City of Portland
Development Review Application
Planning Division Transmittal Form

Application Number: 2015-097 **Application Date:** 06/10/2015
CBL: 057 J031001 **Application Type:** Level III Site Plan Under 50,000 sq f
Applicant: Briggs Street Property LLC /Nicholas Burnett
Project Name: Briggs Street Apartments
Address: 5 BRIGGS ST
Project Description: 3 Unit rental apartment residential structure at 5 Briggs in the West End
Zoning: R6

Briggs Street Subdivision: Three Units Apartments
5 Briggs Street
Level III Subdivision and Site Plan Review
2015-097
Briggs Street Property, Applicant

Prepared by: Shukria Wiar, Planner
Date: July 24, 2015

Drawing file: 1. Original Plans / C1.0 Subdivision Recording Plat.pdf

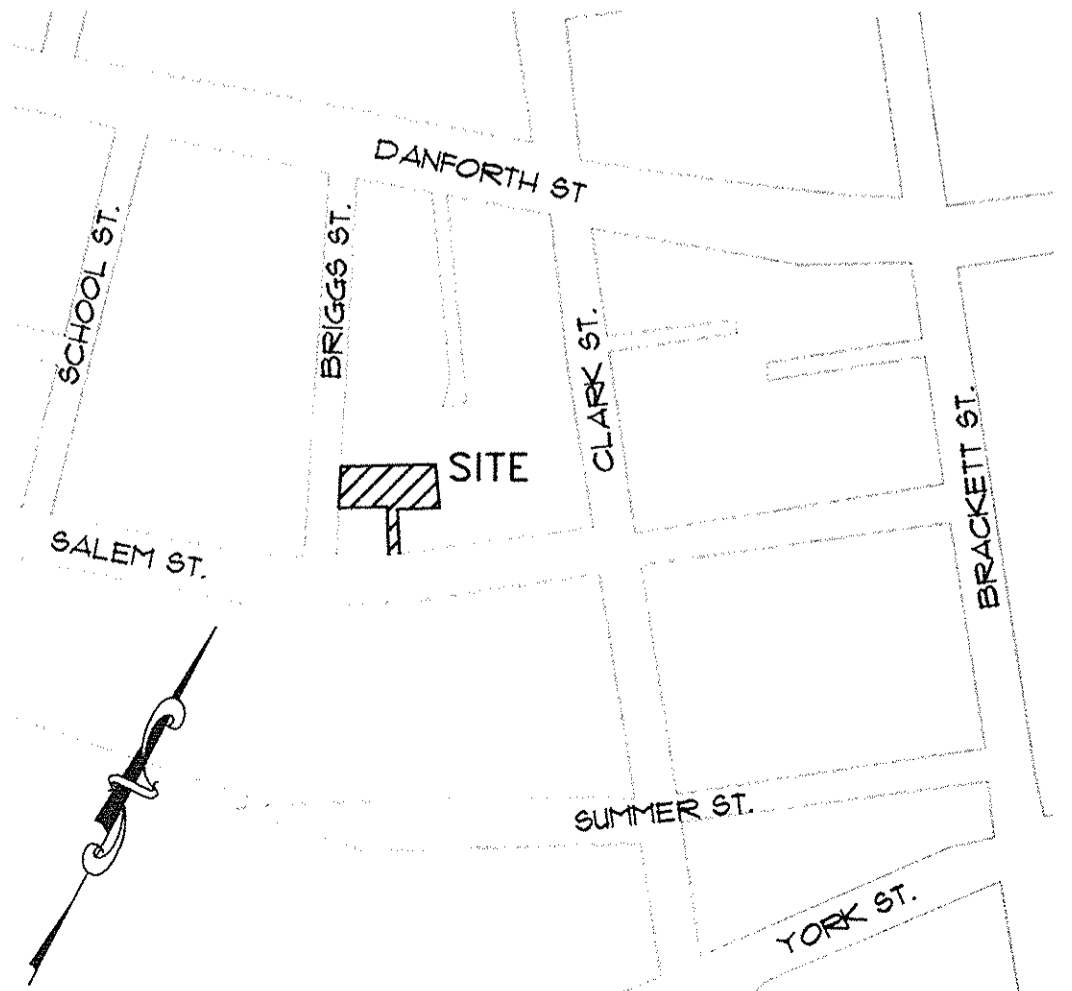
The applicant has submitted a recording plat. The plat will need to note the number of proposed units and associated parking on site. The final plat will need to be revised to reflect any waivers and conditions of approval that relate to the subdivision plan. Any waivers granted must be recorded at the Registry of Deeds within 90 days of a Planning Board decision. As writing of this report, there are no waivers requested.
